14 September 2011

**Major Project 11_0048 – Residential Development – Buildings 6, 9, 10 & 17
61 Mobbs Lane - Epping - Channel 7 Site (Epping Park)**

1 Section 1
1 : 100

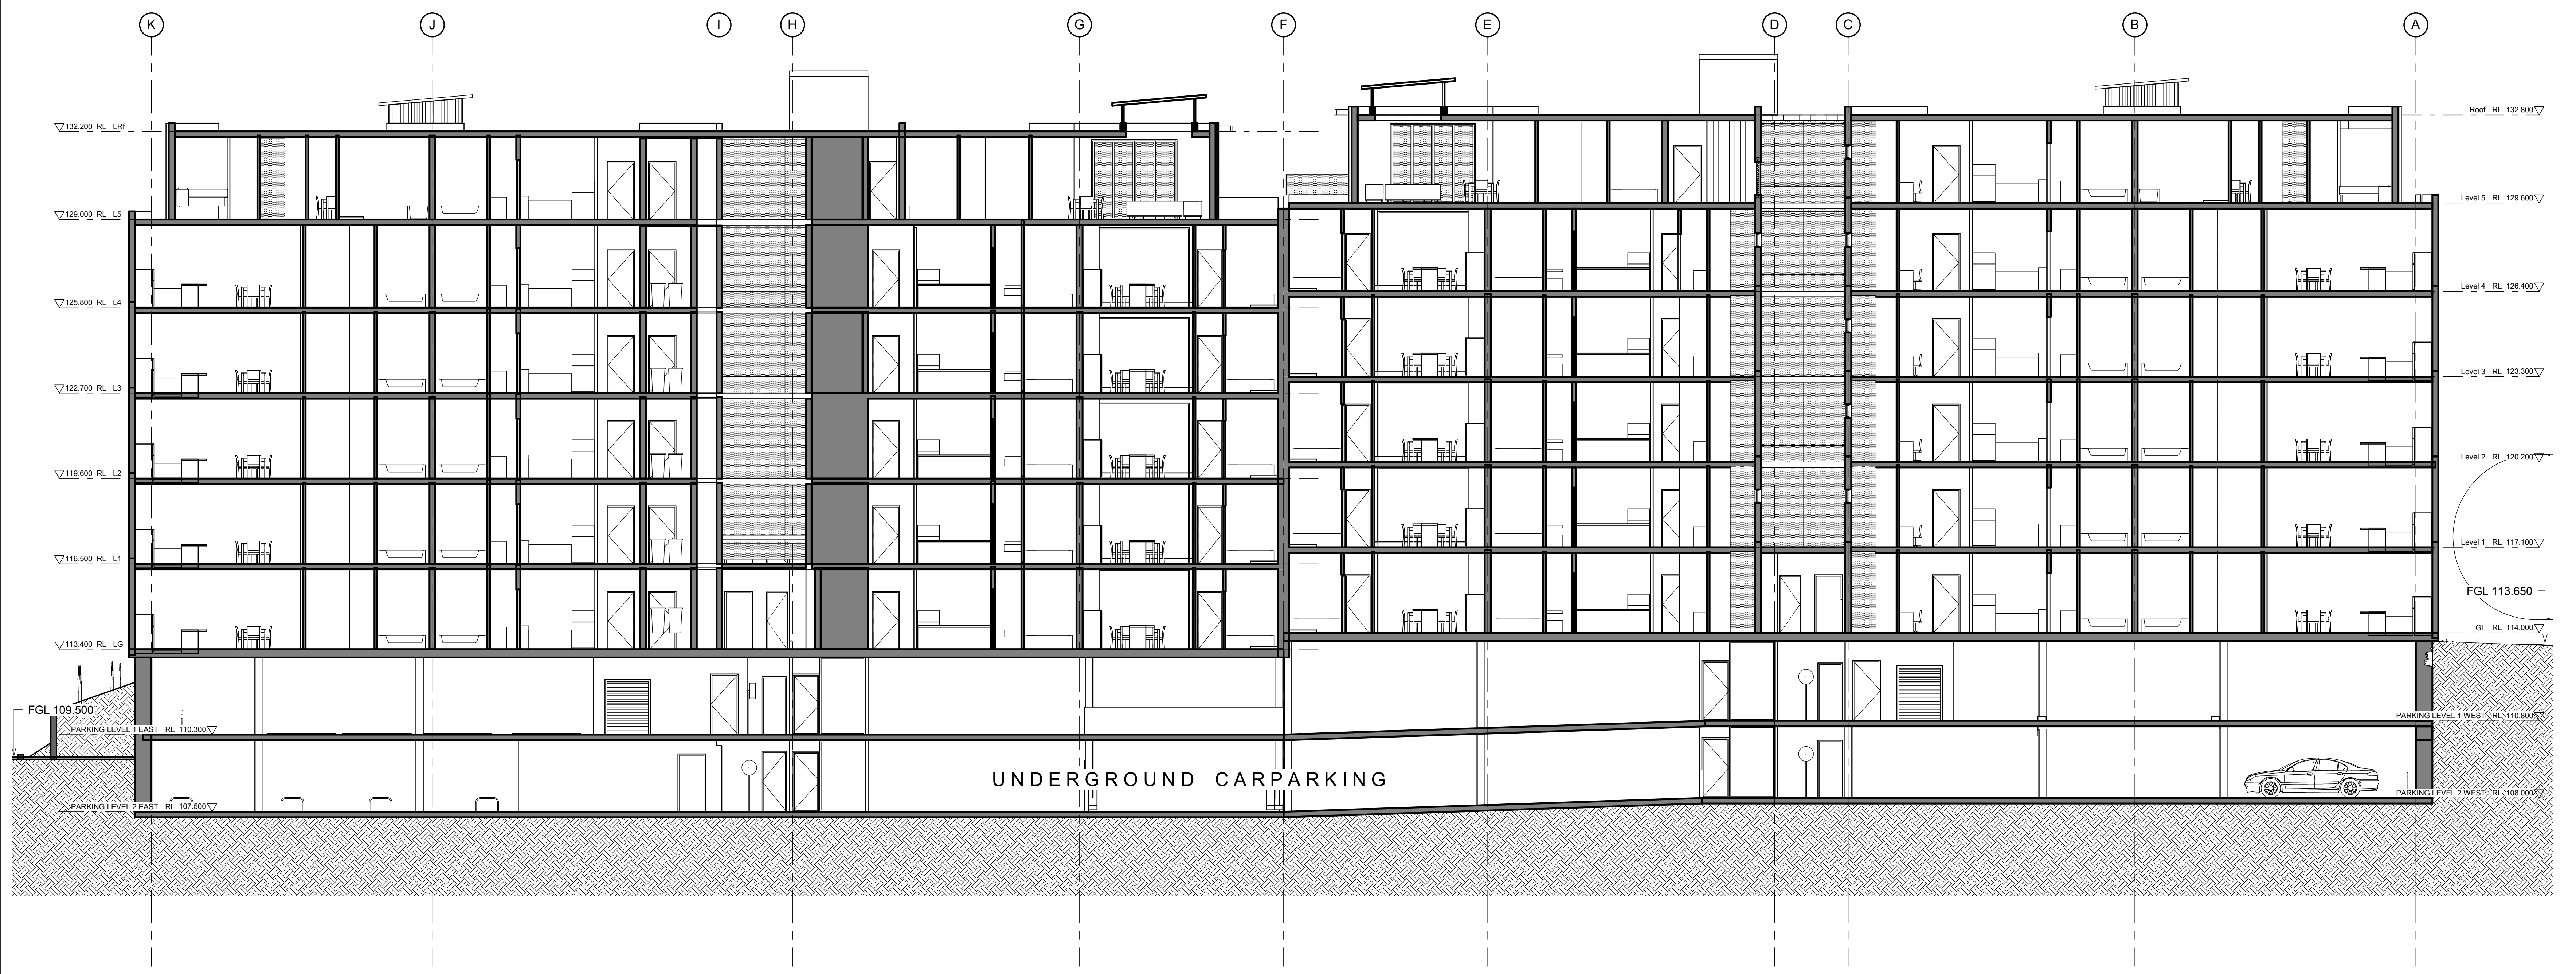
In addition, Section 1 (Drawing No. A0630 Rev E) and the south-western elevation (Drawing No. A0620 Rev E) both indicate that the building is 7 storeys in height. This appears to include the pool and gymnasium (Parking Level 1) and the 6 levels of residential located above.

1 SECTION A
1:100

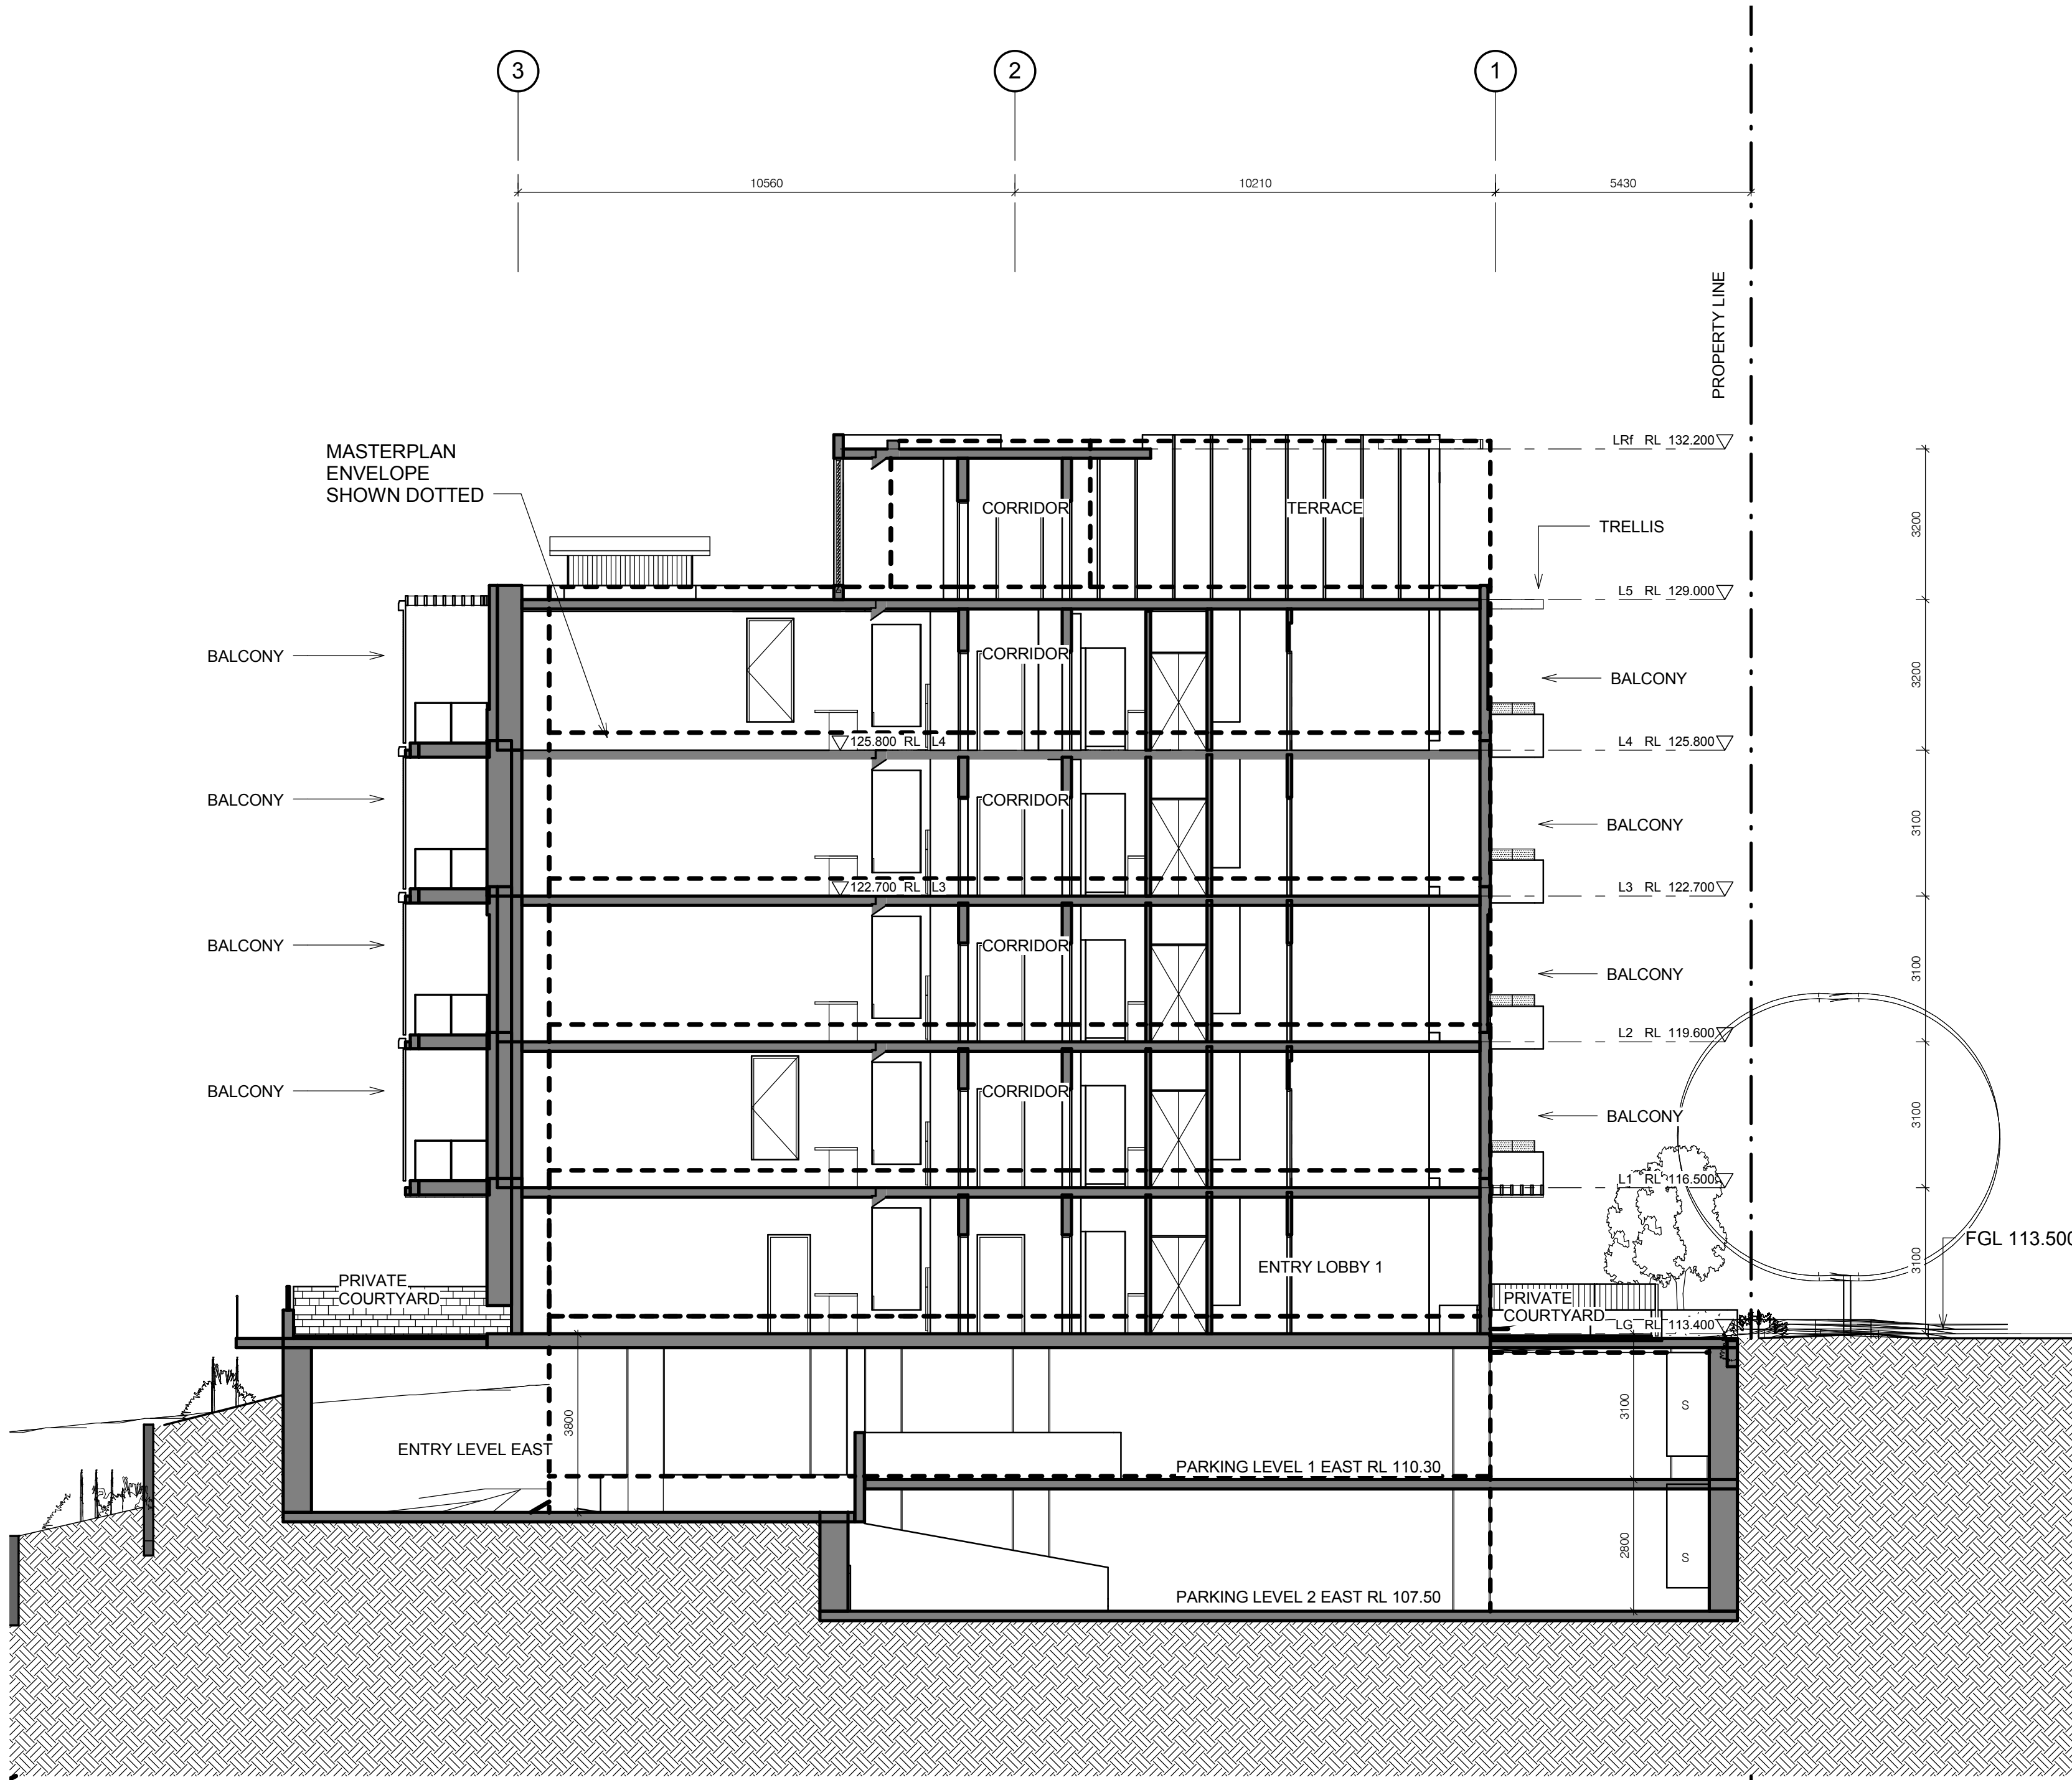
In addition, concern is raised with the significant projection of the basement - Carpark Level 1 as shown on Section A (Drawing No. A0930). This basement appears as a storey and results in a building which is 7 storeys in height.

This proposed height does not comply with the approved modified Concept Plan.
